2024/0275

Description: Outline application with all matters reserved for residential development of site following demolition of existing building

Wembley Works, Hemingfield Road, Hemingfield, Wombwell, S73 0LY

Site Plan
1 : 500

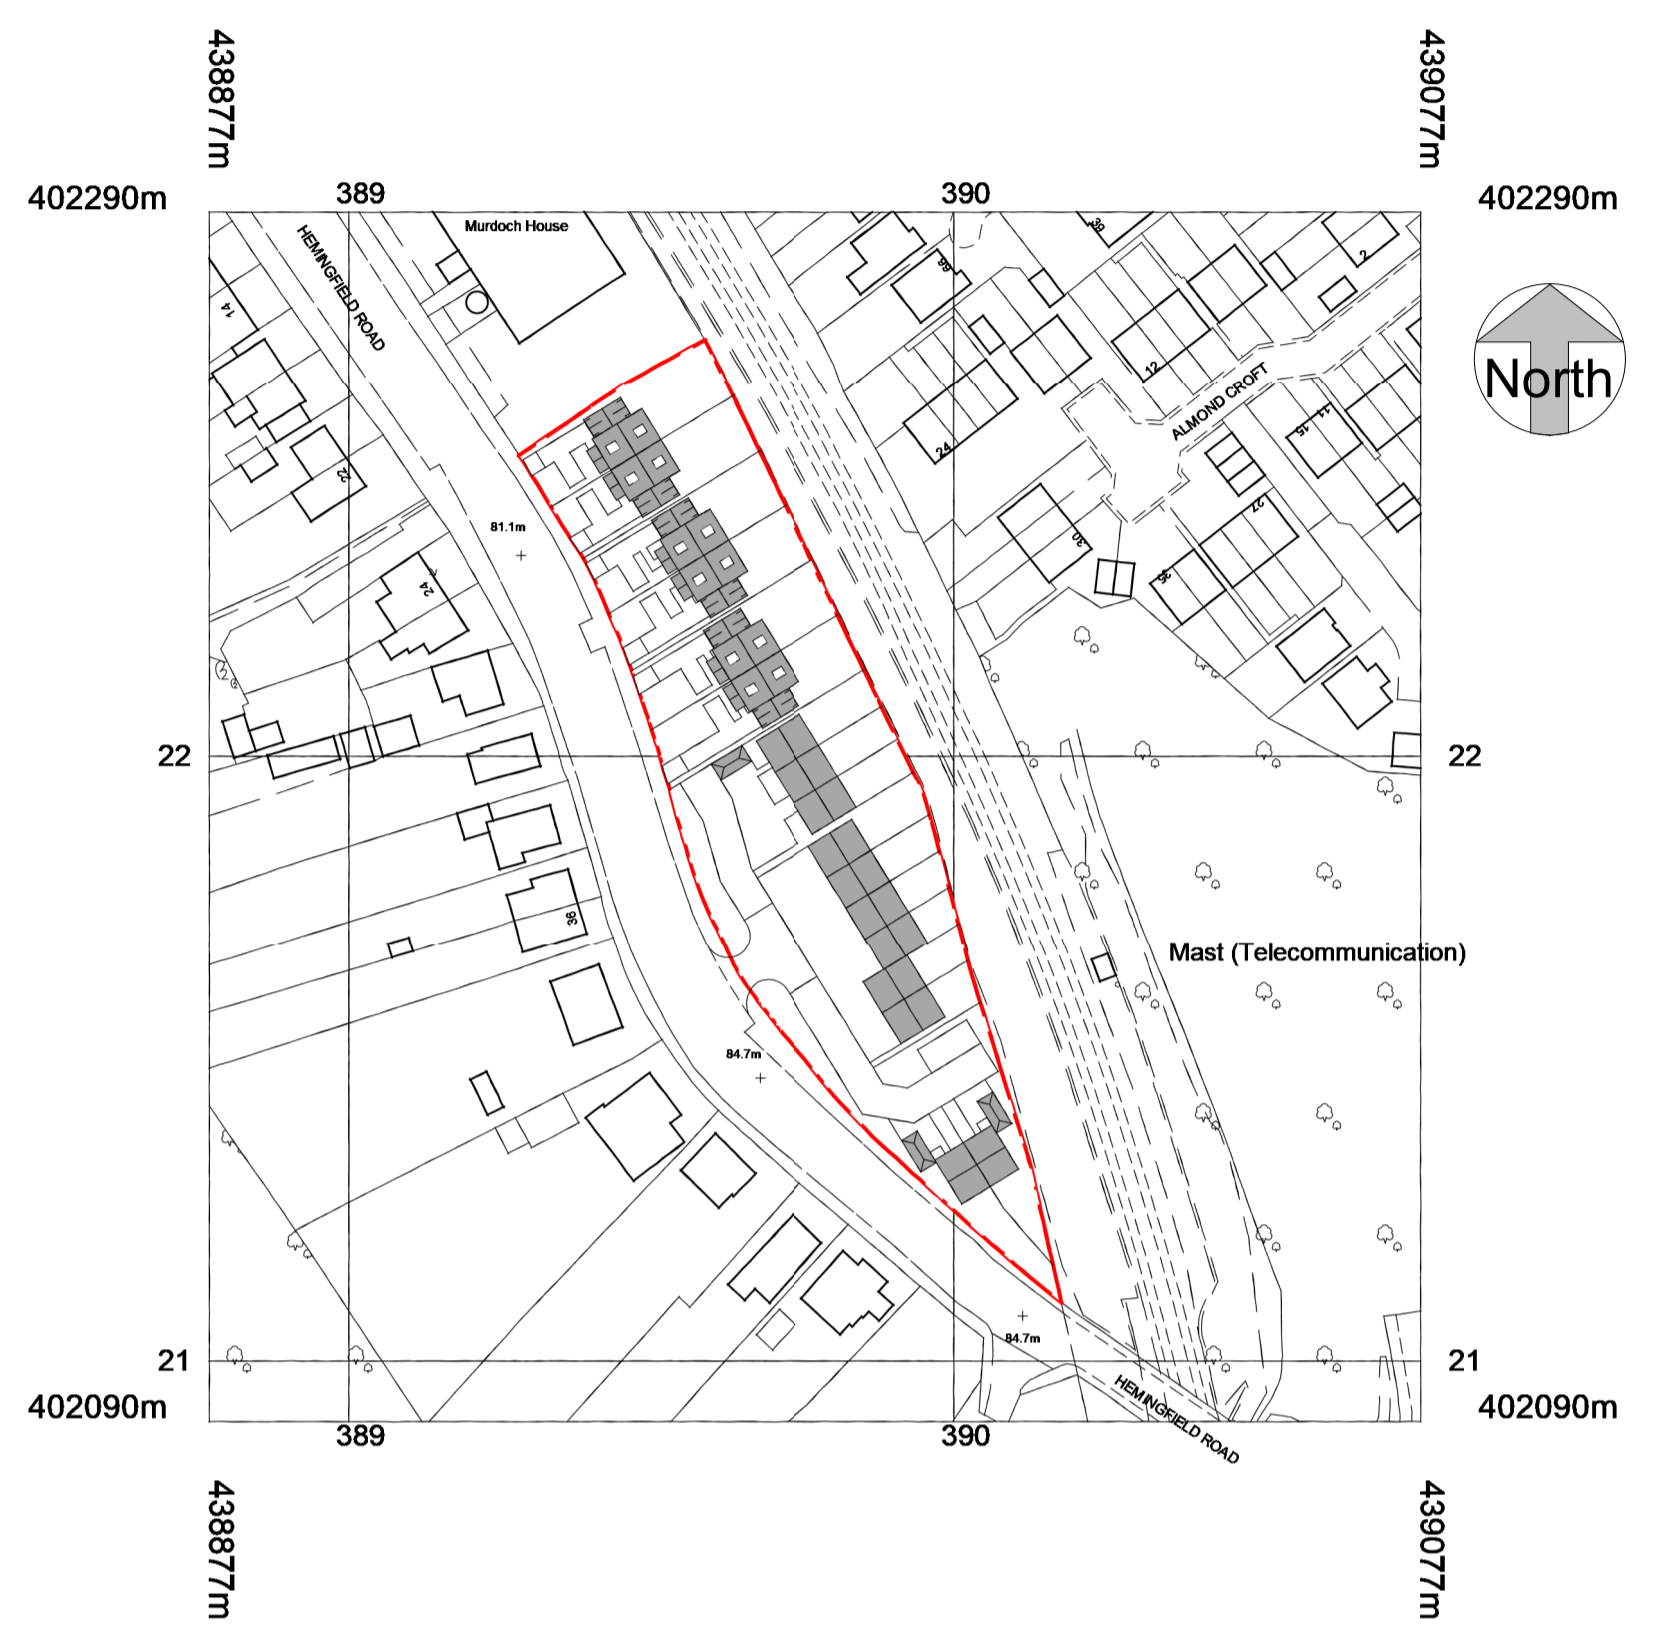
Highways – don't object to the principle of development but the illustrative layout would not be acceptable.

It is difficult to judge the full impact on residential amenity given the proposed layout is indicative and the application is in outline. The layout is cramped in places, with small gardens, however this would be subject to further assessment at reserved matters stage.

It is noted that the applicant is seeking outline permission with all matters reserved and whilst there is no objection to the principle of residential development on this site in highway safety terms, the layout provided does give cause for concern.

Hemmingfield Road is classified and as such, all units with direct access will need sufficient room within the site curtilage to enable cars to turn and exit in a forward traveling direction. The turning areas indicated on the plan do not provide sufficient space to manoeuvre within the curtilage. There is sheltered parking provision along the site frontage which will be impacted upon, resulting in the loss of a number of spaces due to the introduction of individual access points. It is also noted that there is a bus stop that has not been indicated on the site plan that will impact access/egress to the site. Plots 7-17 would require an adoptable carriage layout due to the number of units served with refuse collection carried out from within the site however there is clearly insufficient room to enable access for such a large vehicle. The indicative layout appears over intensive and there may need to be a significant reduction in units for residential development to be deemed acceptable on this site.

Therefore, although the layout is indicative at this stage, the number of access points proposed is cause for concern as is the overall number of units and the illustrative layout is not supported in highway safety terms in accordance with Local Plan Policy T4. However as the proposal is wholly in outline and it appears that the site is capable of being adequately accessed and designed to address highway safety issues, this issue weighs moderately in favour of the proposal.

Greenspace – The illustrative masterplan includes no provision for onsite greenspace, however, as the proposed is for less than 20 units it would not trigger a requirement for off site contributions.
